From: Sarah Jolley [REDACTED]
Sent: 01 June 2022 13:41
To: Planning.Responses <Planning.Responses@arun.gov.uk>
Cc: Sue Wallsgrove [REDACTED]
Subject: RE: Planning Consultation on: BN/50/22/PD

Application No: BN/50/22/PD

Site Address: 37A Hill Lane Barnham PO22 0BL

Description of Works: Prior notification under Schedule 2, Part 3, Class MA for the change of use from Class E to 1 No dwelling house (C3).

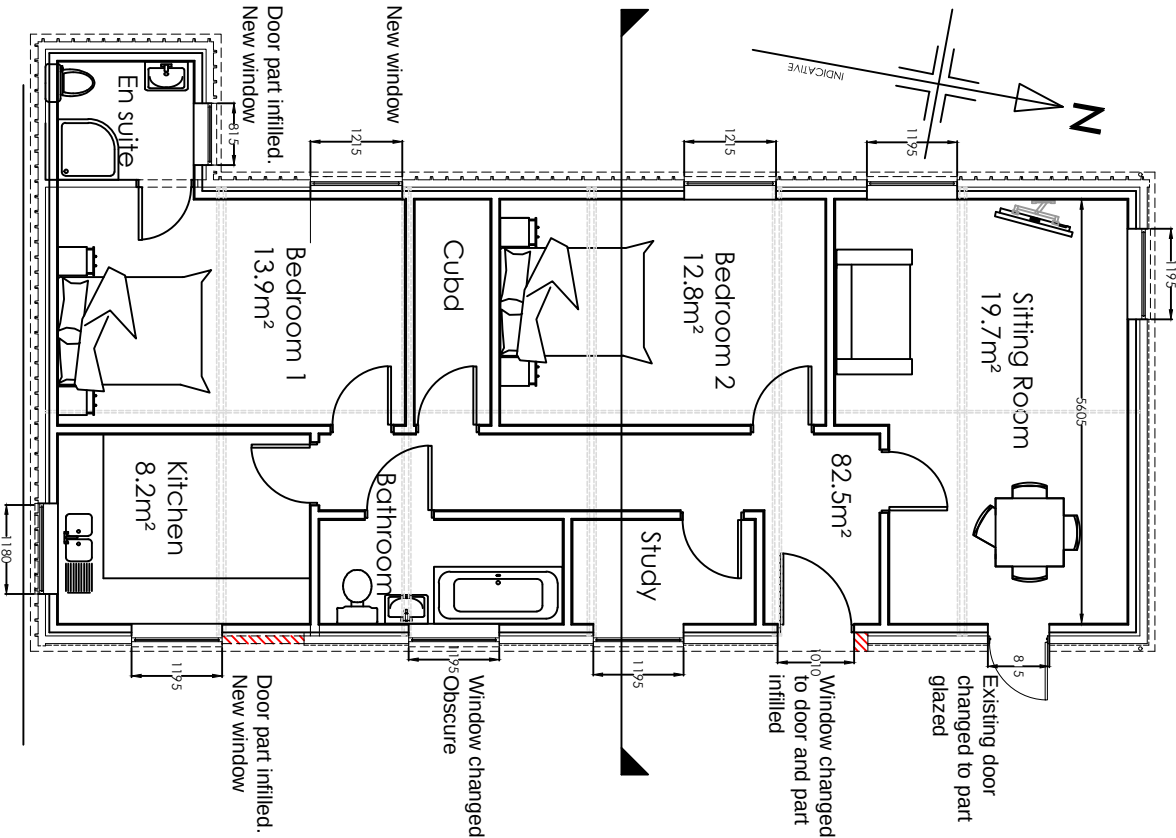
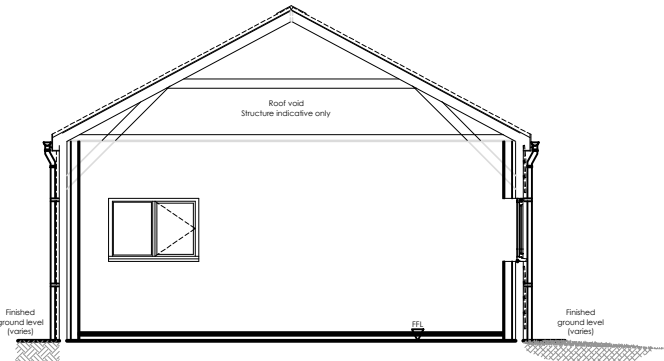
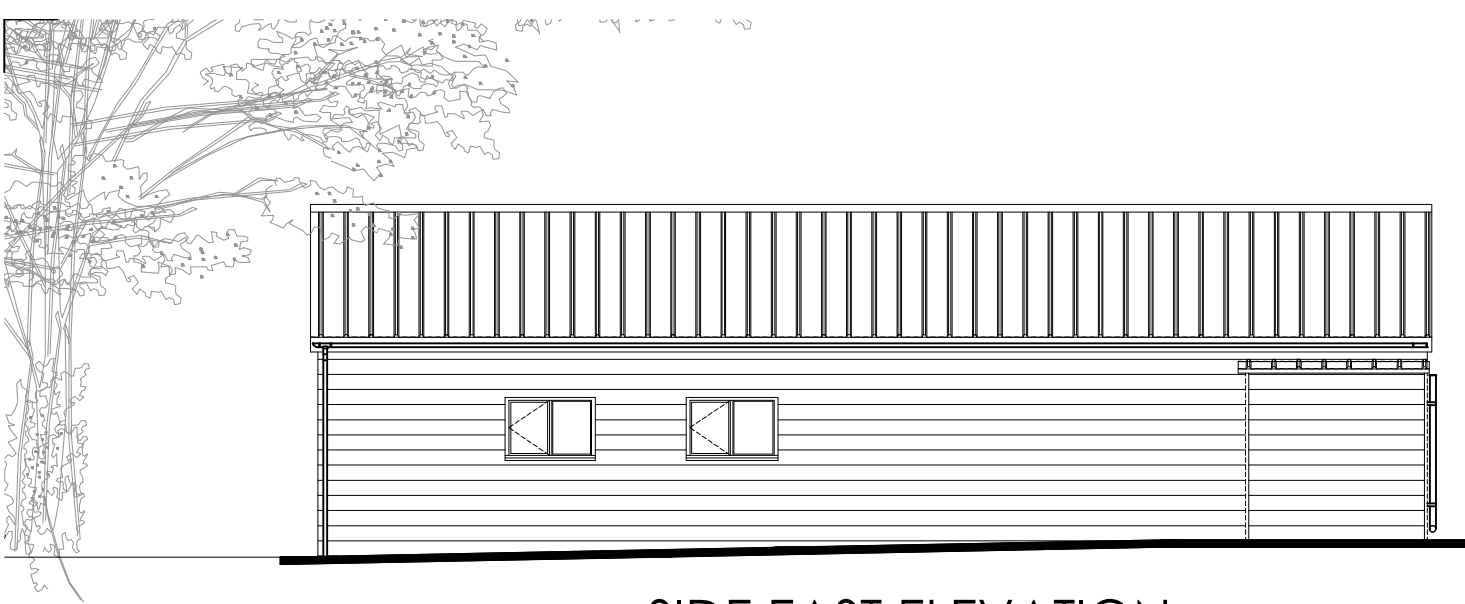
It was also noted that there is a tree located adjacent to the proposed property and this needs to be retained.
